Consultation response from Drainage & Coastal Engineers.

APPLICATION NO: AL/107/16/RES

Registered: 03-OCT-16
Site Address: Land West of Westergate Street & East of Hook Lane
Westergate PO20 3TE

P.Cann comments on current proposals based on Drg. BSO/E4462/031 Rev D.

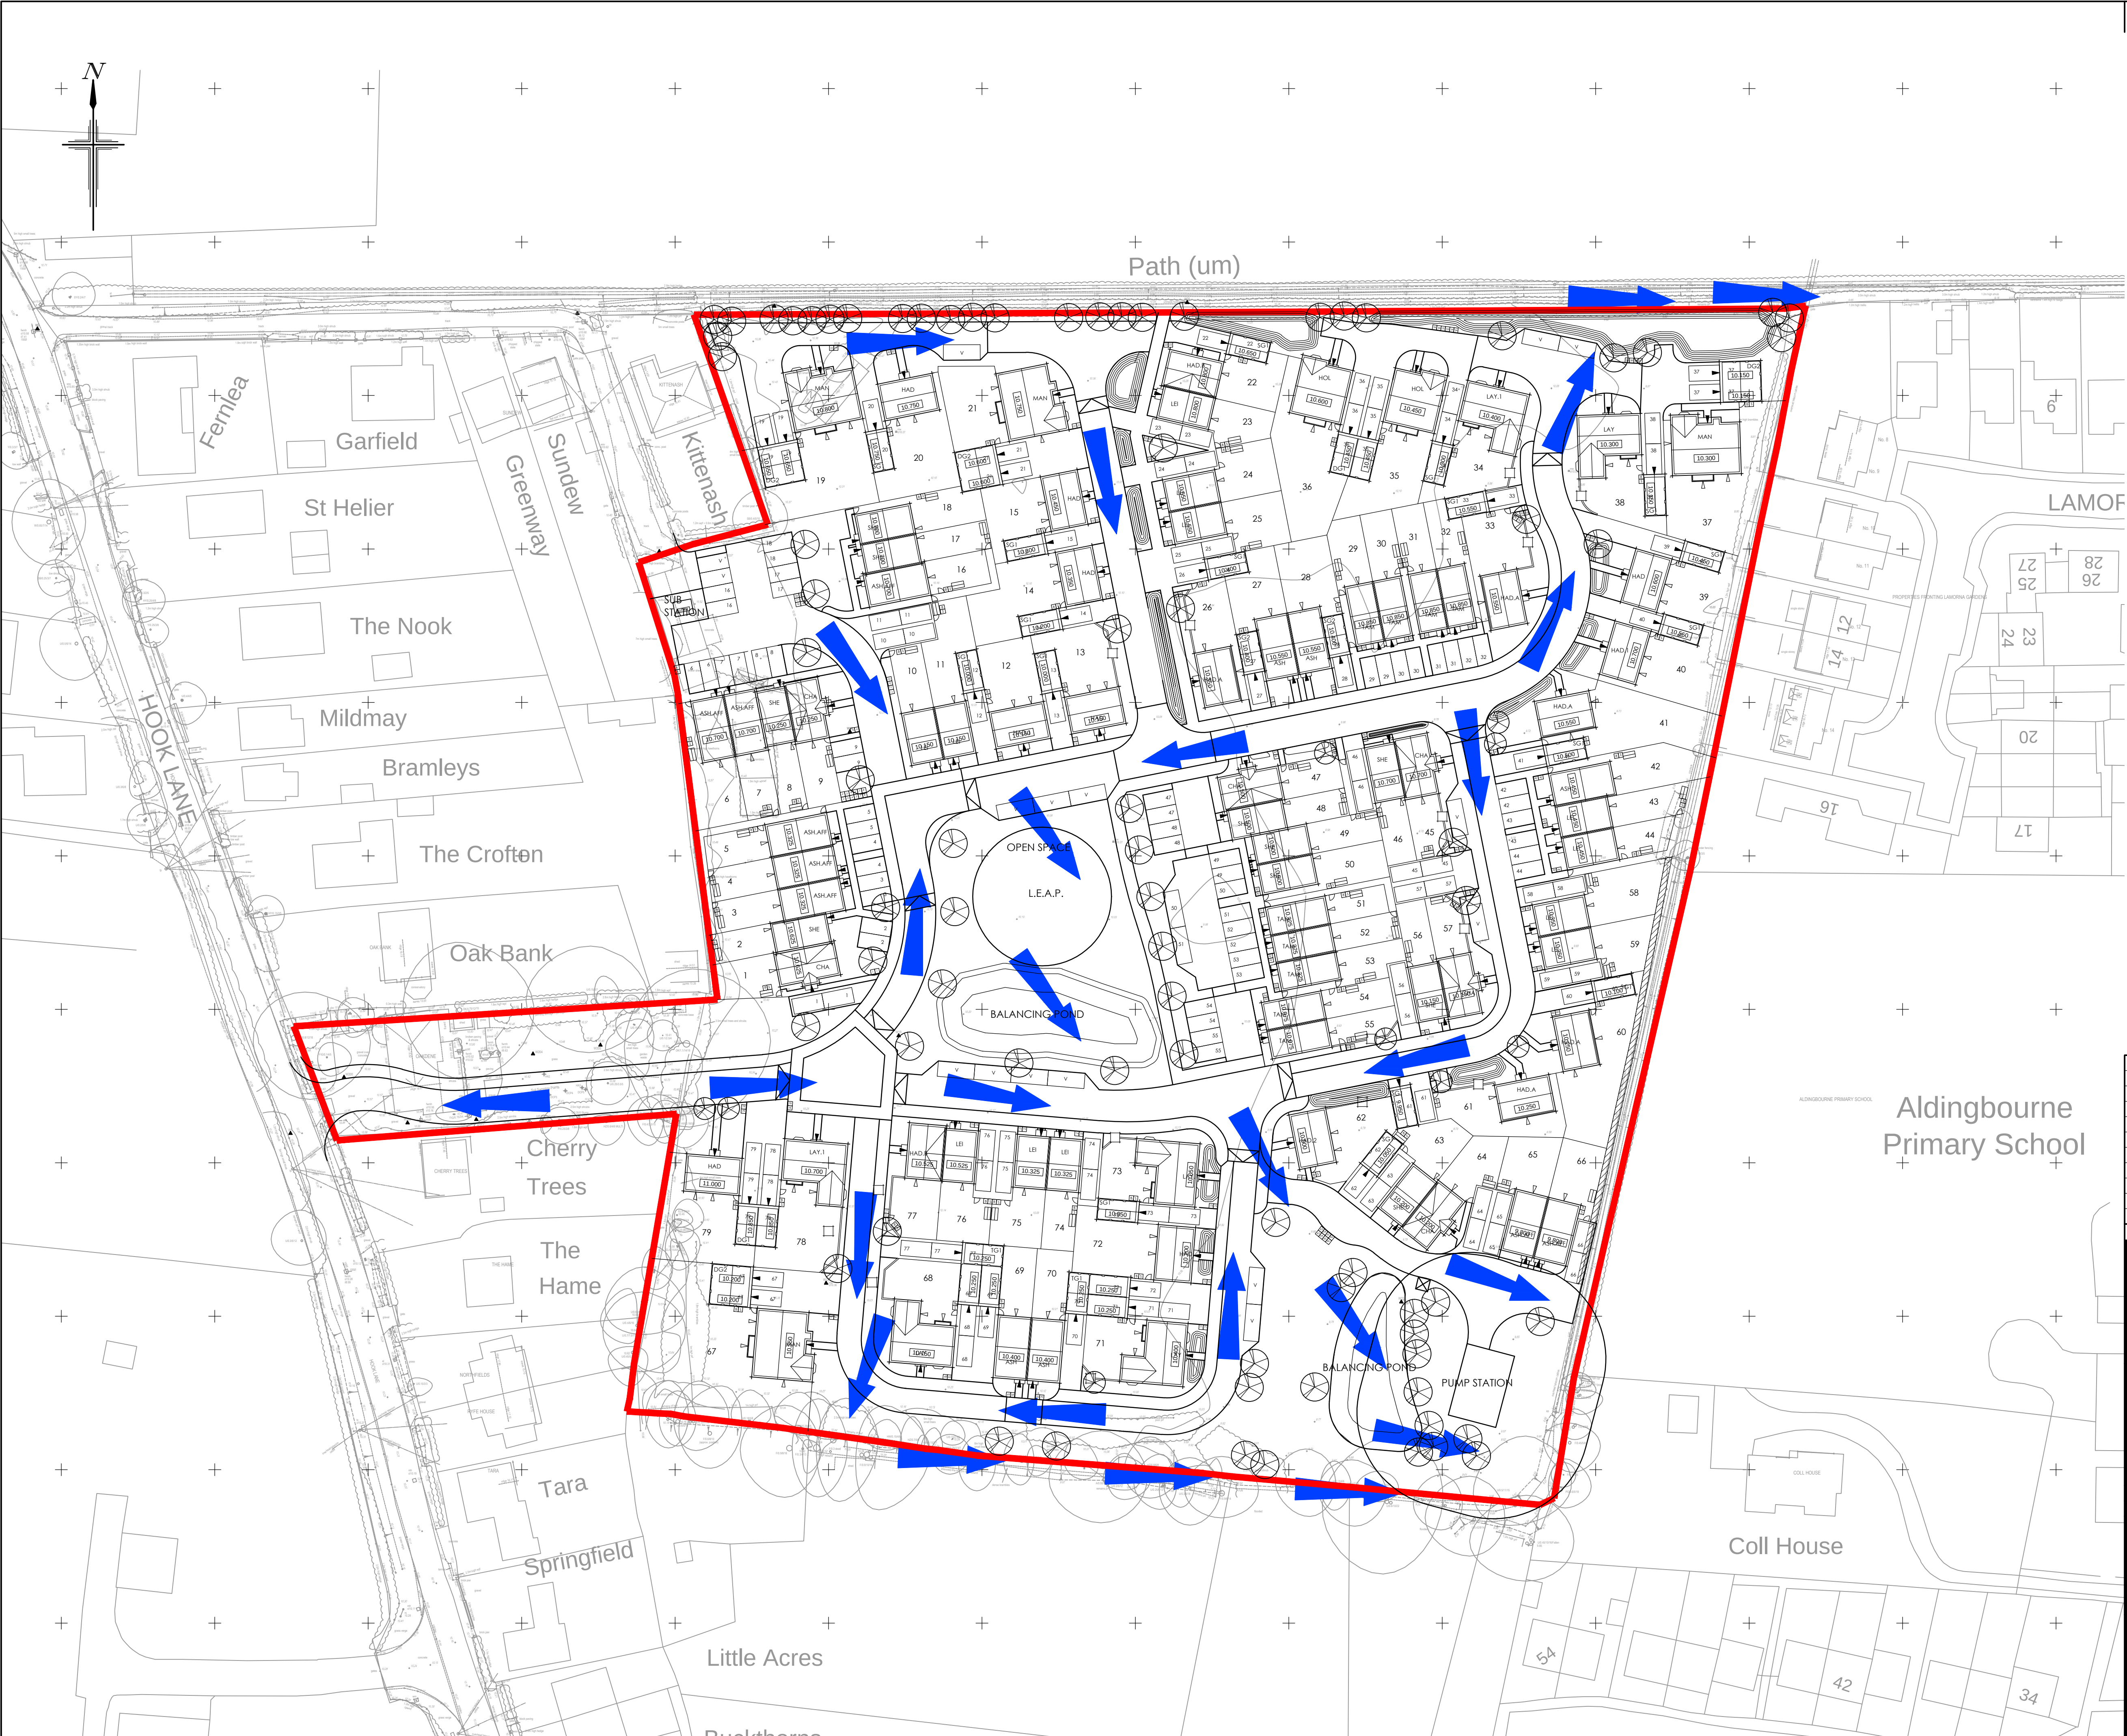
1. No consideration given to a linked permeable paved roads/swale system, avoiding the need for an extensive piped system and thereby reducing overall fall required.

2. The level of any potential buried existing culvert outfall in the SE corner has not been investigated. This is critical in determining whether a pumped option is required, as well as establishing an outfall from the watercourse which is currently heavily silted.

3. Discharge from the site should mimic the three present points of discharge from the field ie. SE corner, NE corner and Eastern boundary. It is also noted that water stands on various sections of the field. Most greenfield runoff flows to SE corner assumed outfall but this is not being utilised! Significant exceedance flows will travel into SE corner.

5. The ditch between the SE outfall and the existing eastern culvert is flat. No consideration given to item 3 above, or the possible buried outfall in the SE corner. They are trying to force water towards the Eastern outfall.

6. No drainage shown for access road into site.
7. Land drainage consent required for culverting of ditch on western boundary.
8. Why can't crates in SE corner be reverted into a pond?

9. Pond near LEAP – safety issues?
10. NE corner of site (0.5l/s discharge) – how will this be achieved? Drainage arrangements not clear in this area.
11. Crates – no chamber access to inlet/outlet pipes.

14. Restricted future access to eastern boundary ditch.
15. Permeable paving outlet pipes not shown
16. Drainage from roofs not shown.
17. Open space used as flood exceedance area.

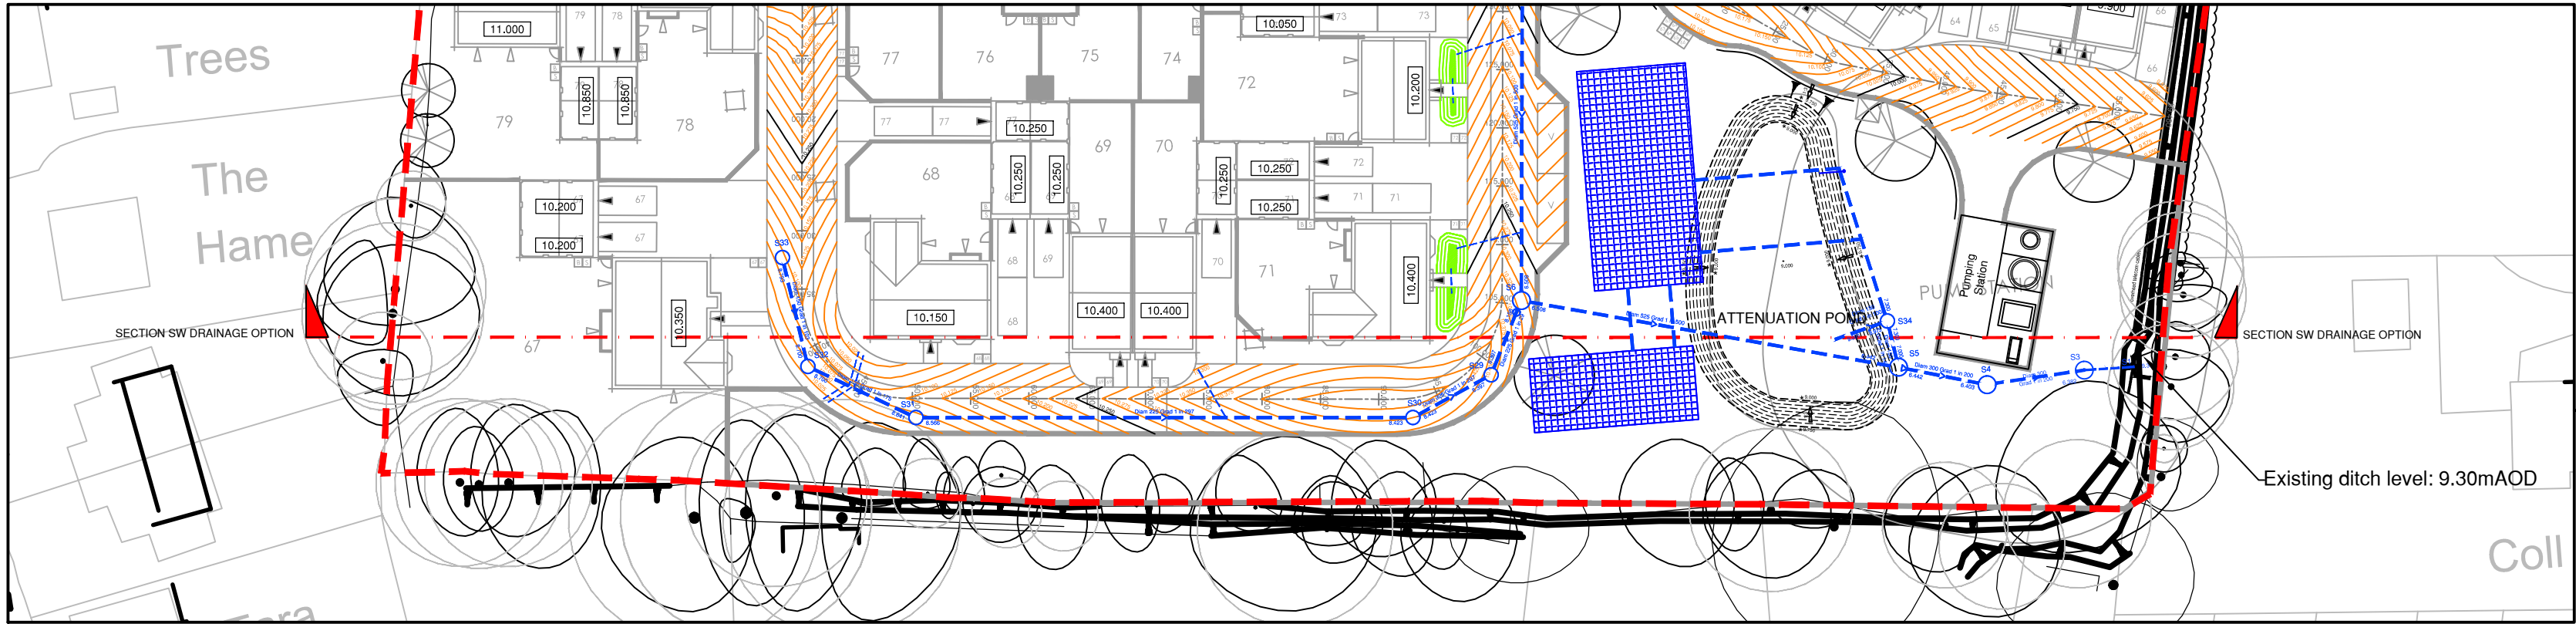
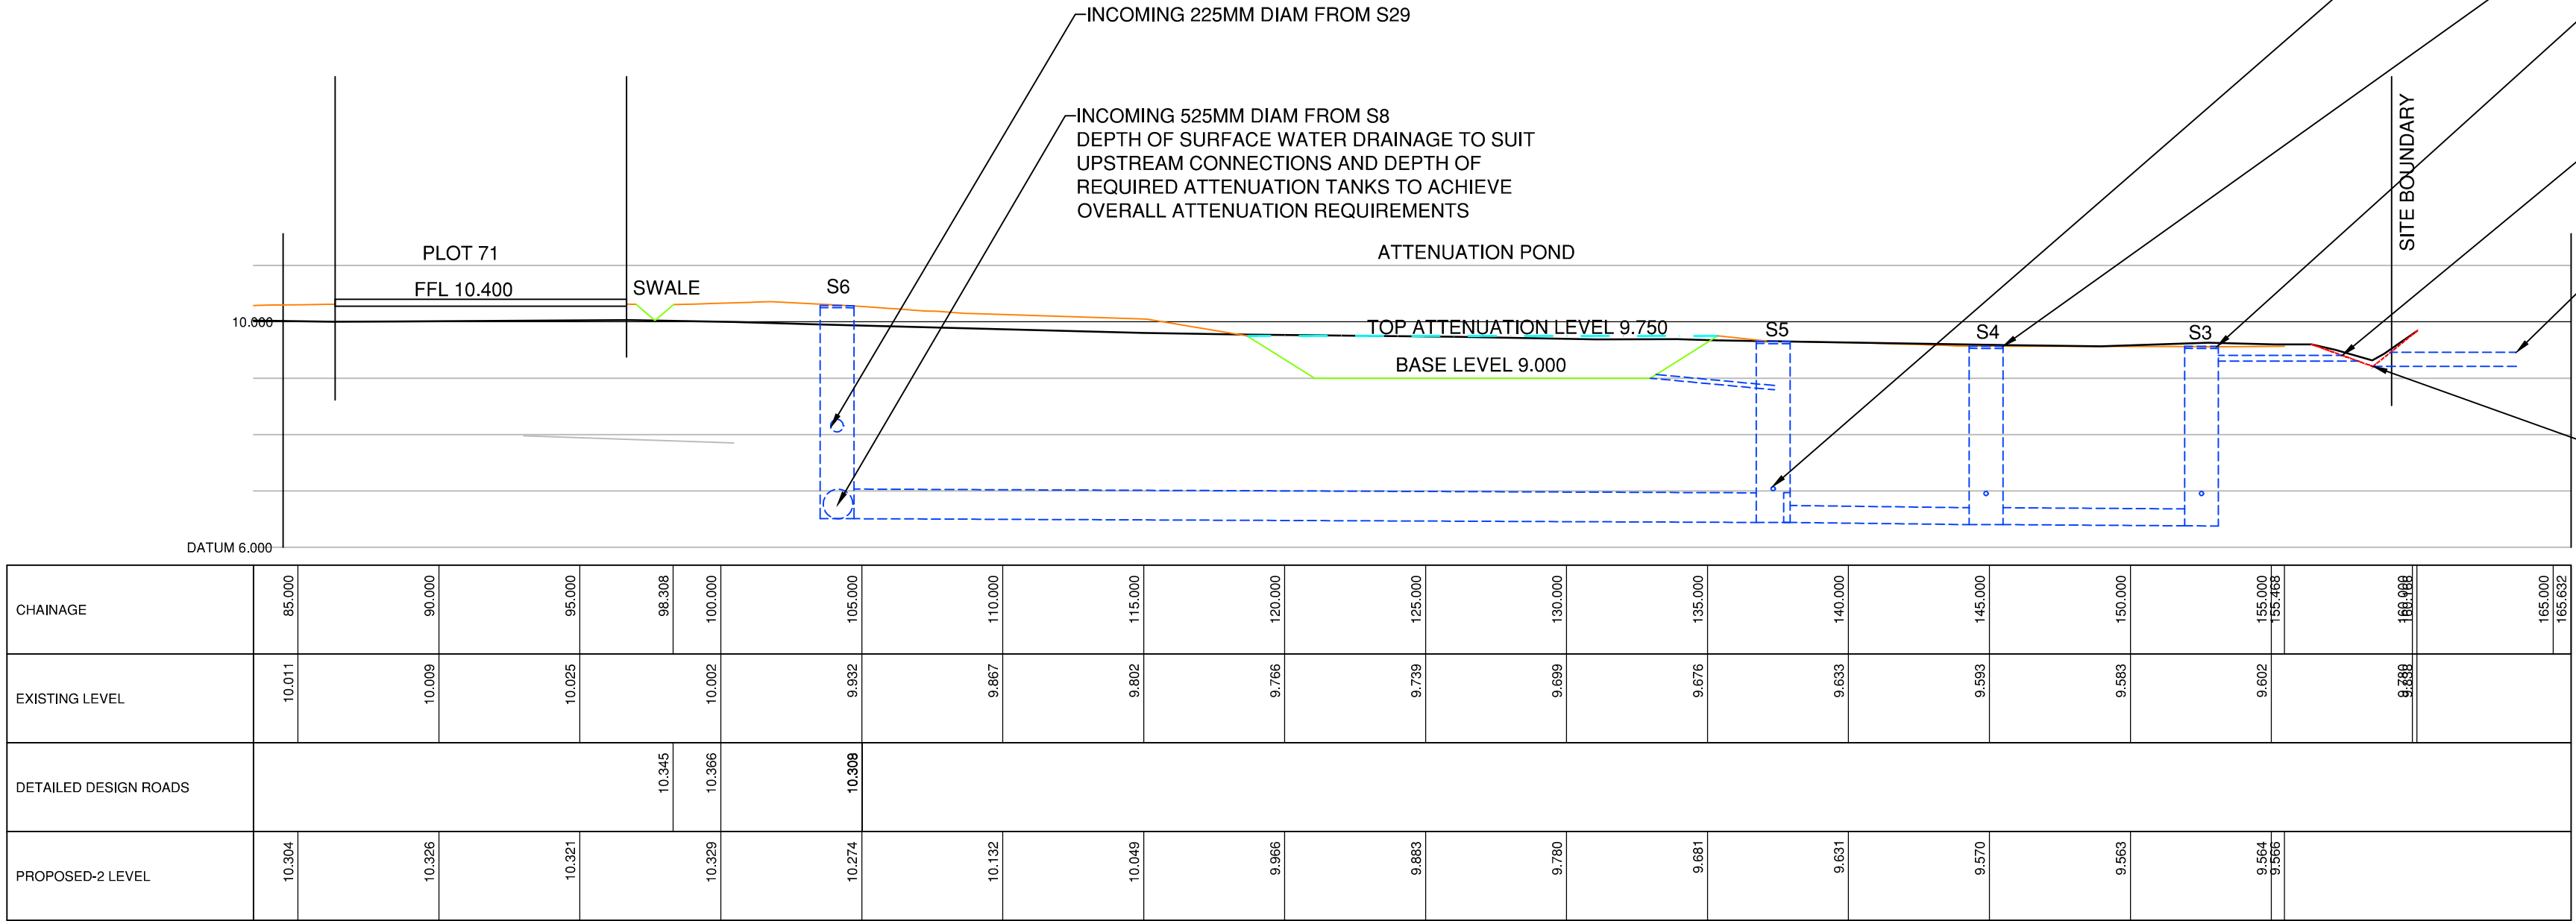
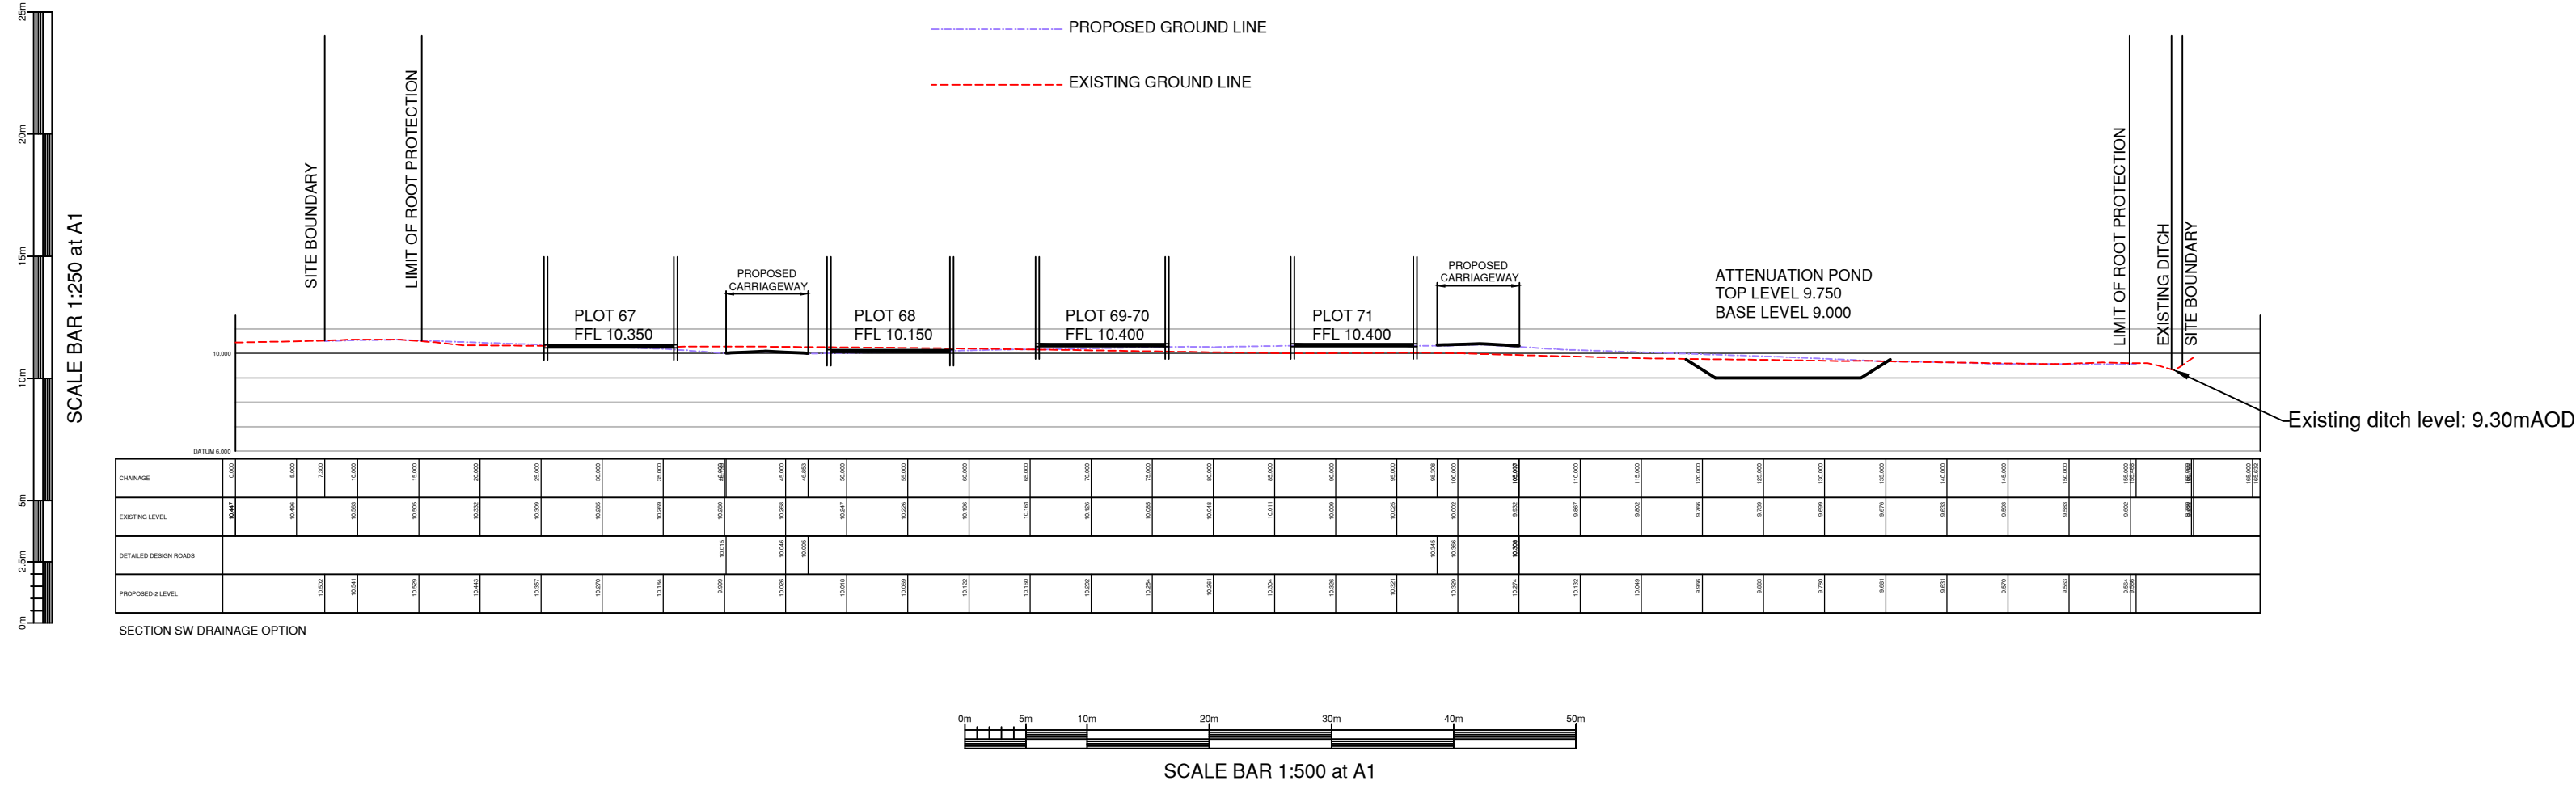
21. Hydrobrake manufacturers technical details
22. Full construction details (specific to each structure) of ponds/tanks/pumping station. Size of pumping station? Access road to pumping station.

23. Concrete bag headwall. All layers to be pinned together – show more clearly on the drawing. Note 5 of drawing noted.

24. Longitudinal sections required & to incorporate all pipelines/storage structures.
25. High level connections to have external backdrops.
26. 100mm freeboard of Eastern outfall above ditch bed is not adequate.
